Our Ref: TR030003

Date: 21 November 2017

Application by Port of Tilbury London Limited for an Order Granting Development Consent for a Proposed Port Terminal at the Former Tilbury Power Station ('Tilbury2')

Advice following issue of decision to accept the application for examination

100
0 10
Millimetres

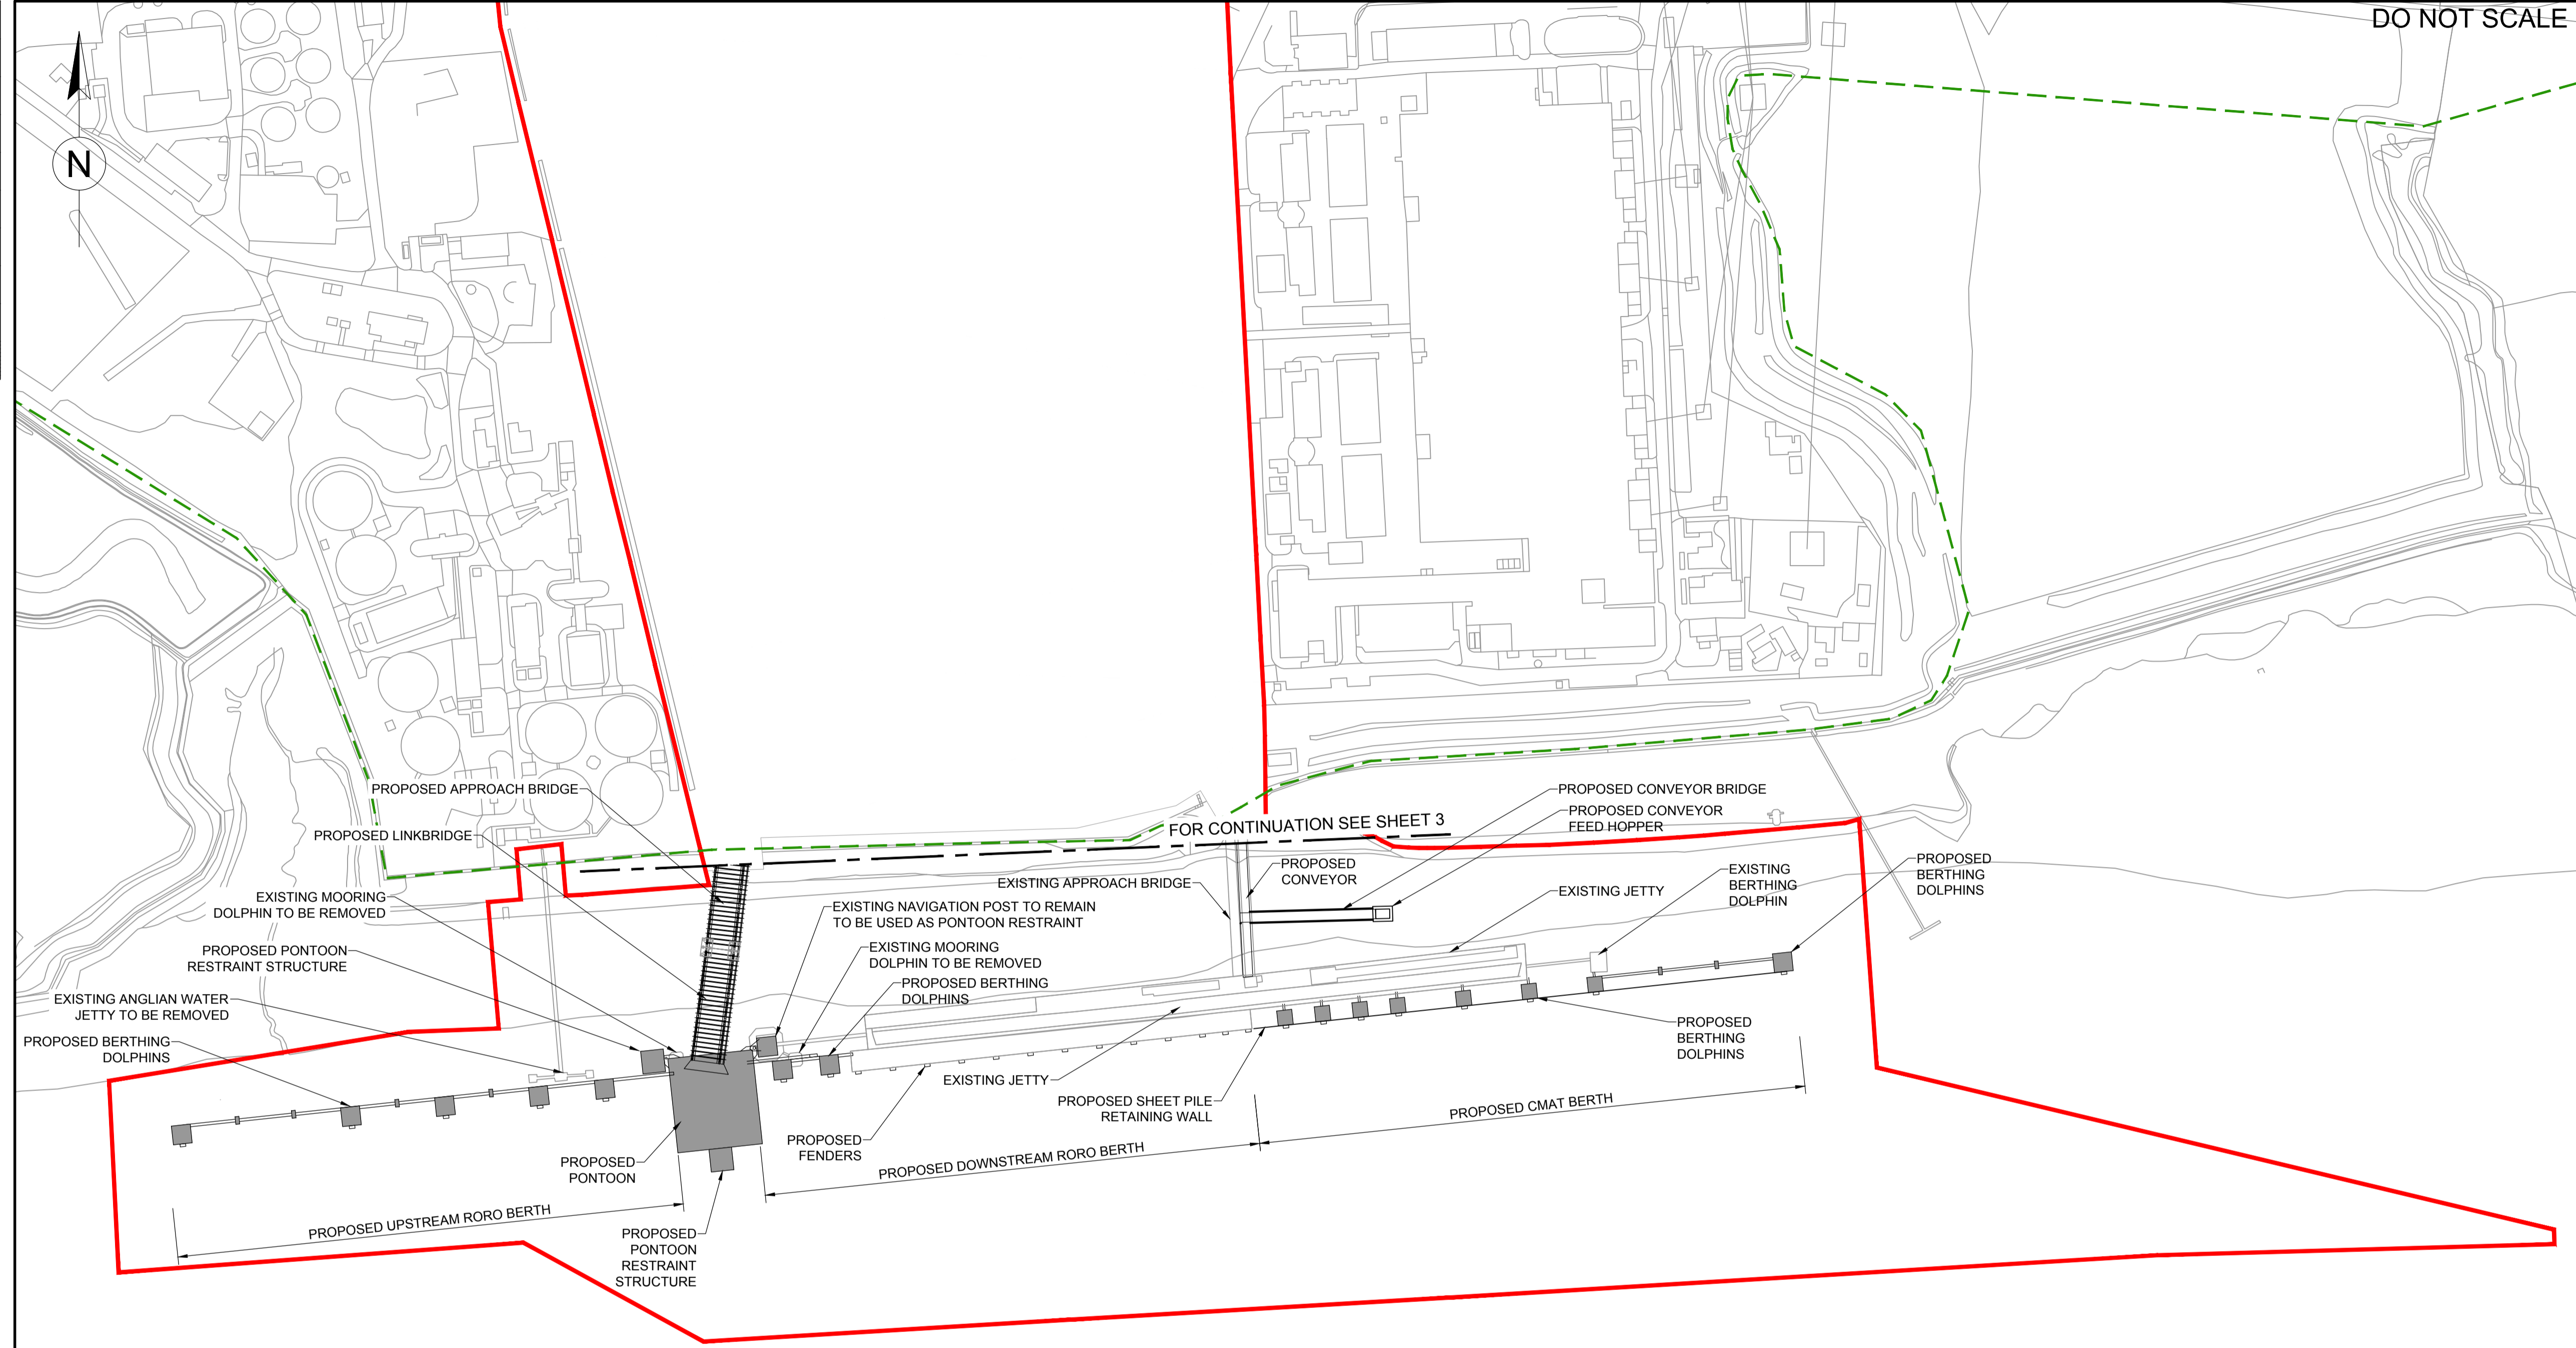
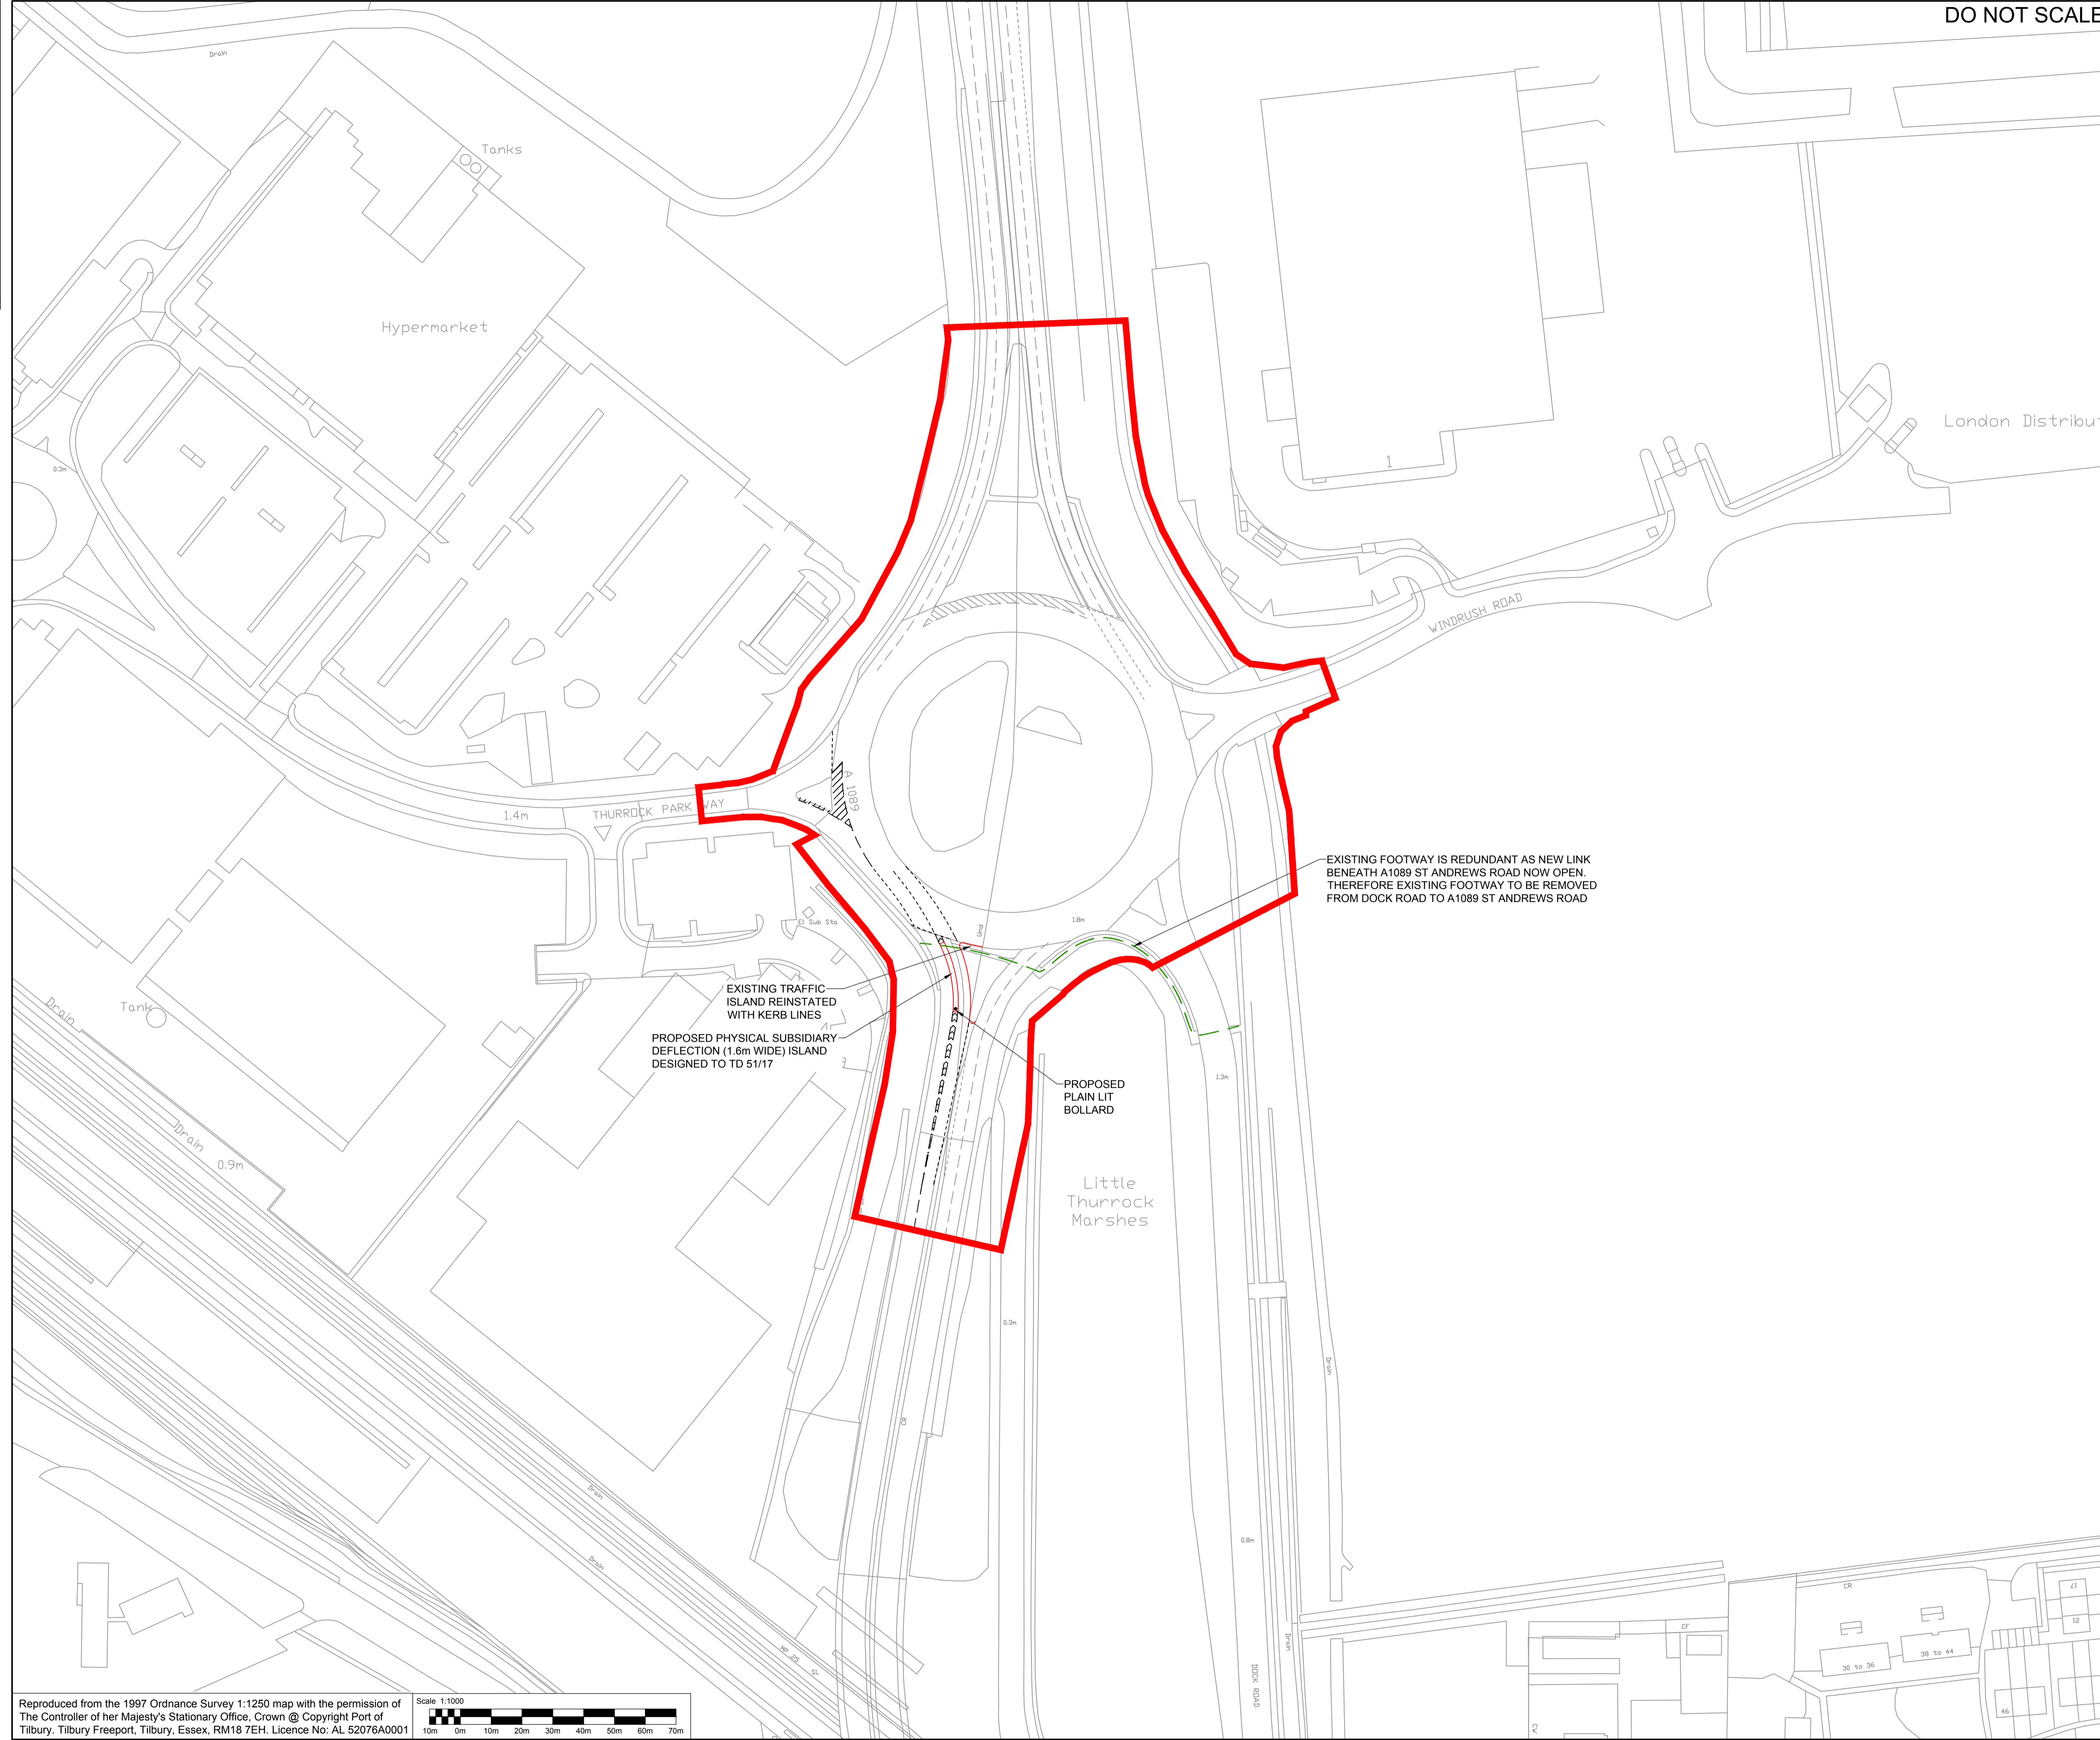
The Engineering Drawings and Plans (Doc 2.9) and the Works Plans (Doc 2.4) state "Do Not Scale". However, they are provided with scale details and a scale bar on each plan. In addition the General Arrangement Plans (Doc 2.2) and Engineering Drawings and Plans state, "Design shown is for illustrative purposes only", (or similar wording). We note that the Engineering Sections and Plans would become a certified document, should the DCO be made. In accordance with APFP Regulation 5(3), a scale is to be provided on these plans and drawings, and the Applicant should prepare for any questions the Examining Authority may have on this point.

Work No.1 includes the alteration and renewal of an existing flood defence. The existing flood wall is identified on the general arrangement plans; however, it is not clear from these plans precisely where the works would take place. Figure 6-3 of the Level 3 FRA (ES Appendix 16.B) contains a figure showing the existing floodwall; however, this figure is not clearly legible. The Applicant should prepare to be asked to revise and submit a new figure(s) to provide absolute clarity including the precise

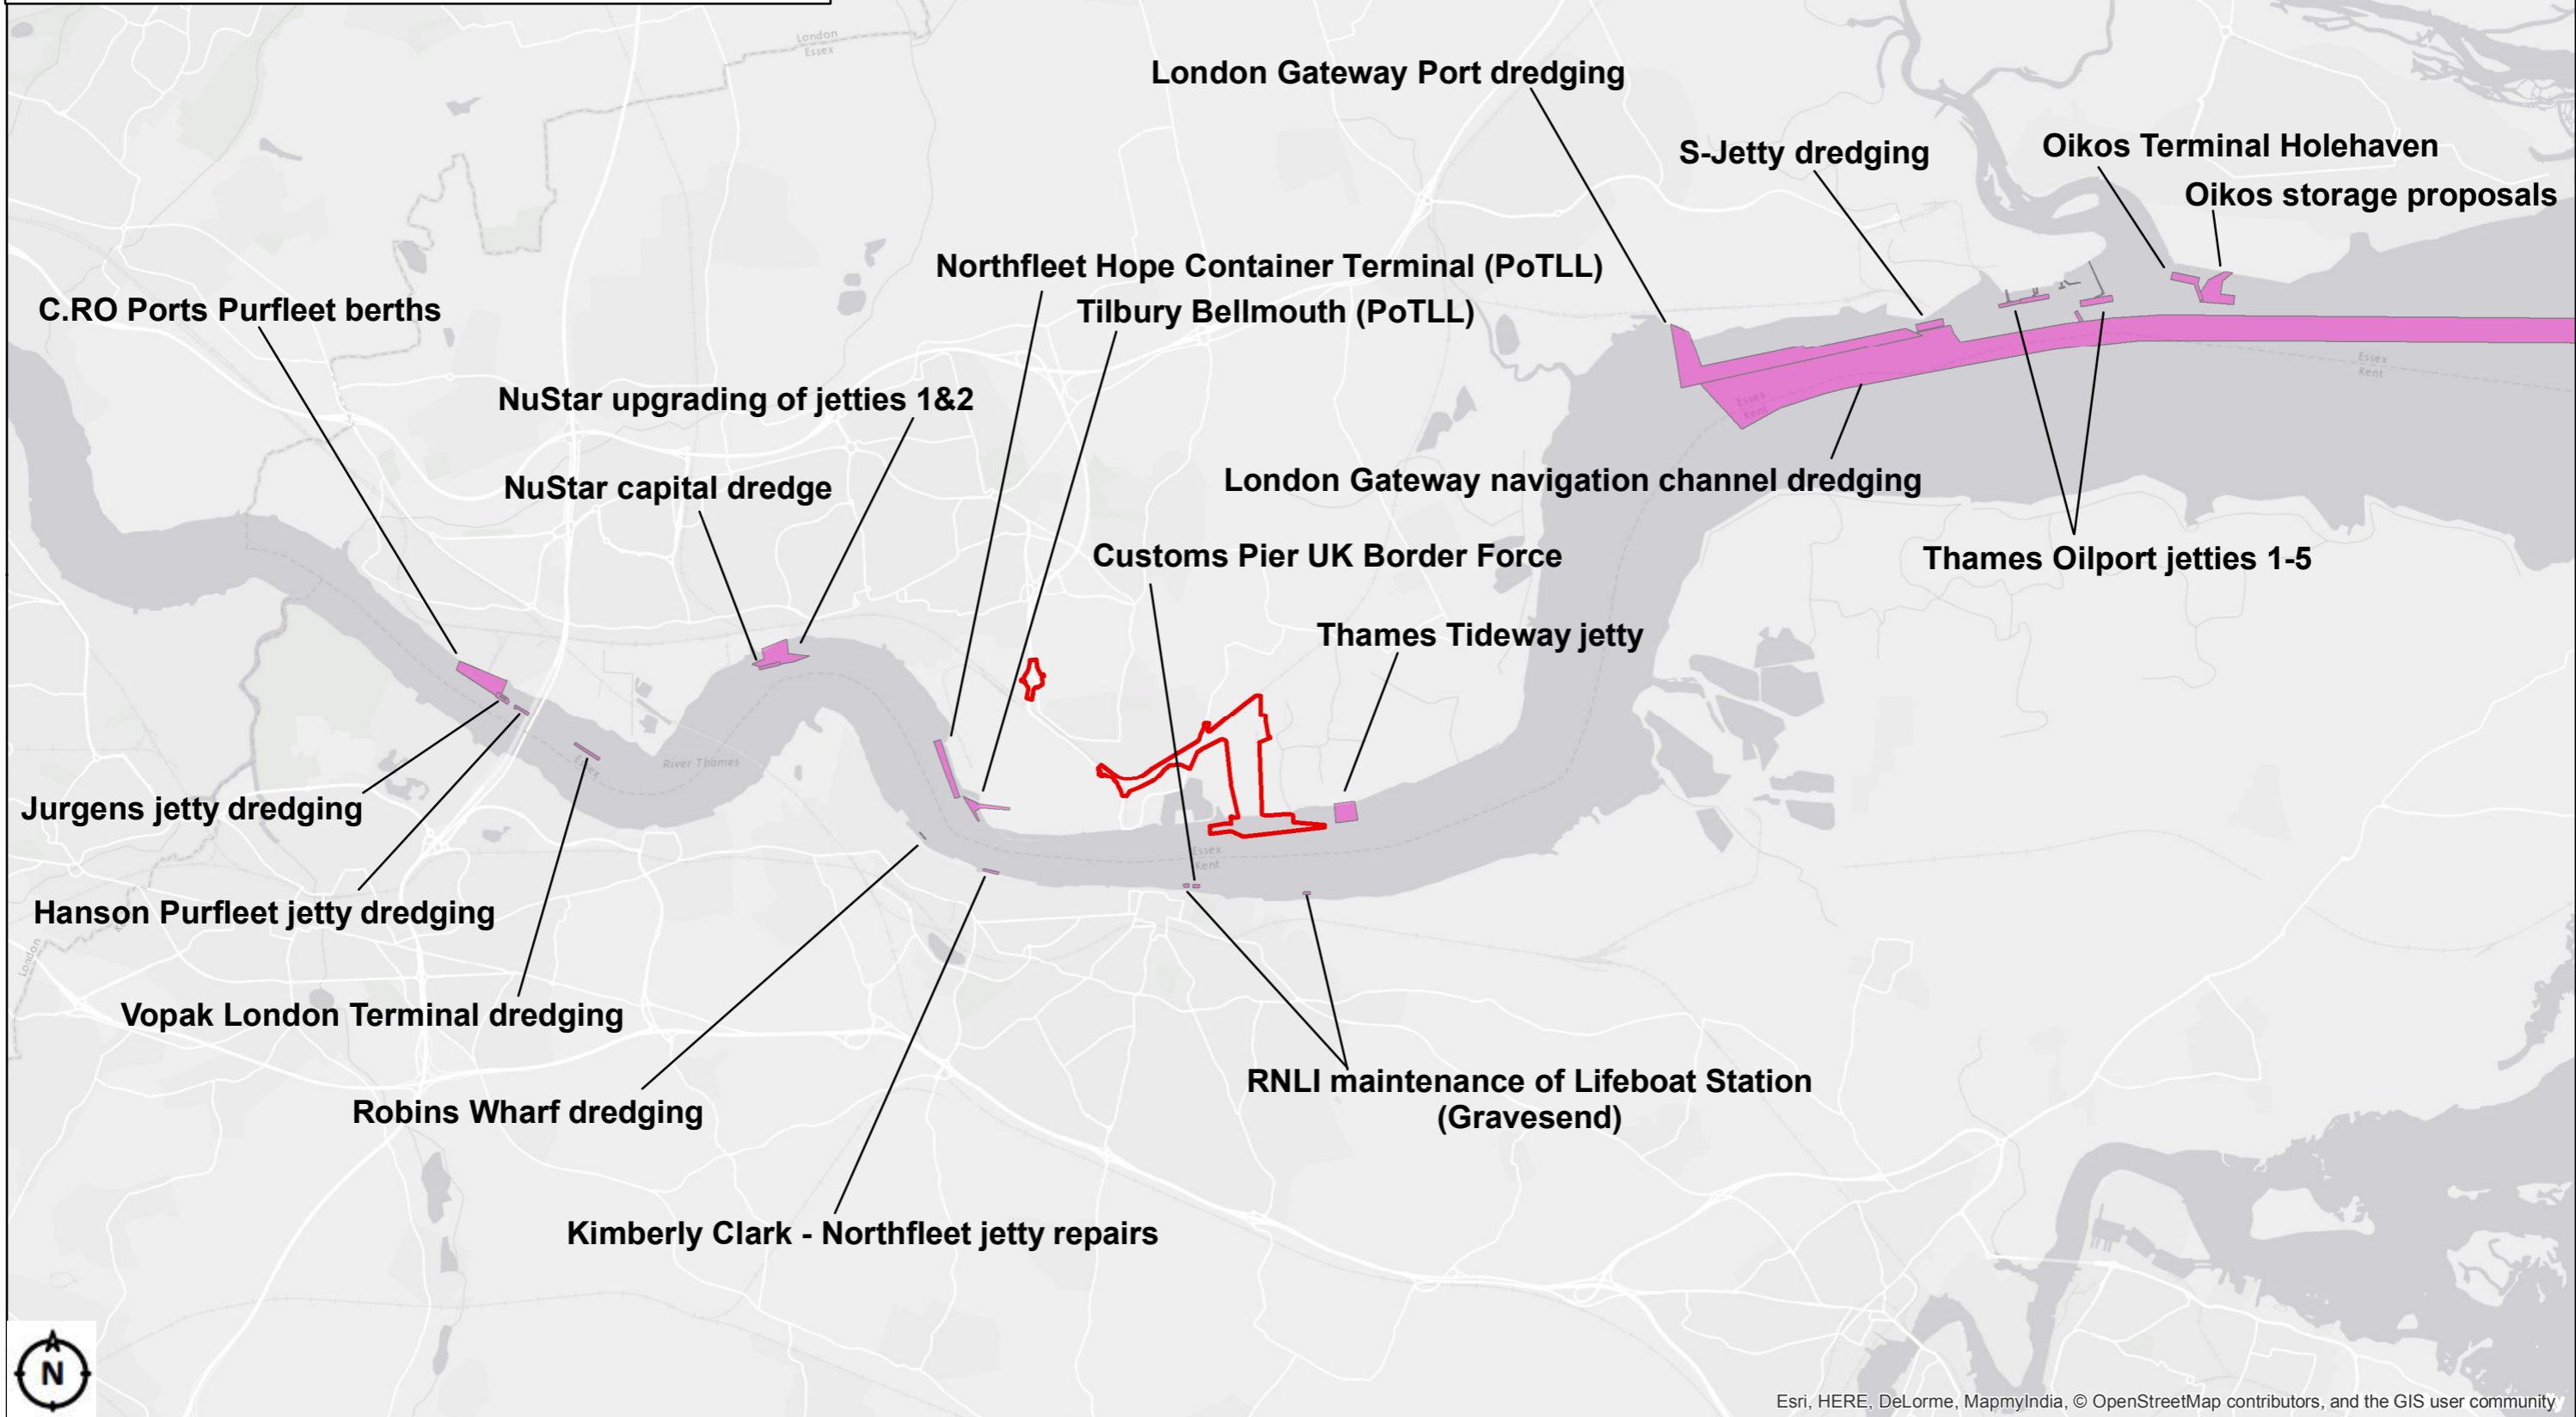
Table 2.2 of the ES identifies projects that have been considered in the cumulative assessment and their locations relative to the Proposed Development are depicted on Figure 11.8. Paragraphs 2.57-2.63 of the ES explain that the proposed Lower Thames Crossing (LTC) is not considered within the cumulative effects assessment because of the limited information available. The Inspectorate notes that subsequent to the application being made for Tilbury2, new information regarding the proposed LTC is now publicly available (including an EIA Scoping Report received by the Inspectorate on 2 November 2017) and should be taken into consideration. The Applicant should provide an assessment of the cumulative effects associated with the proposed LTC.
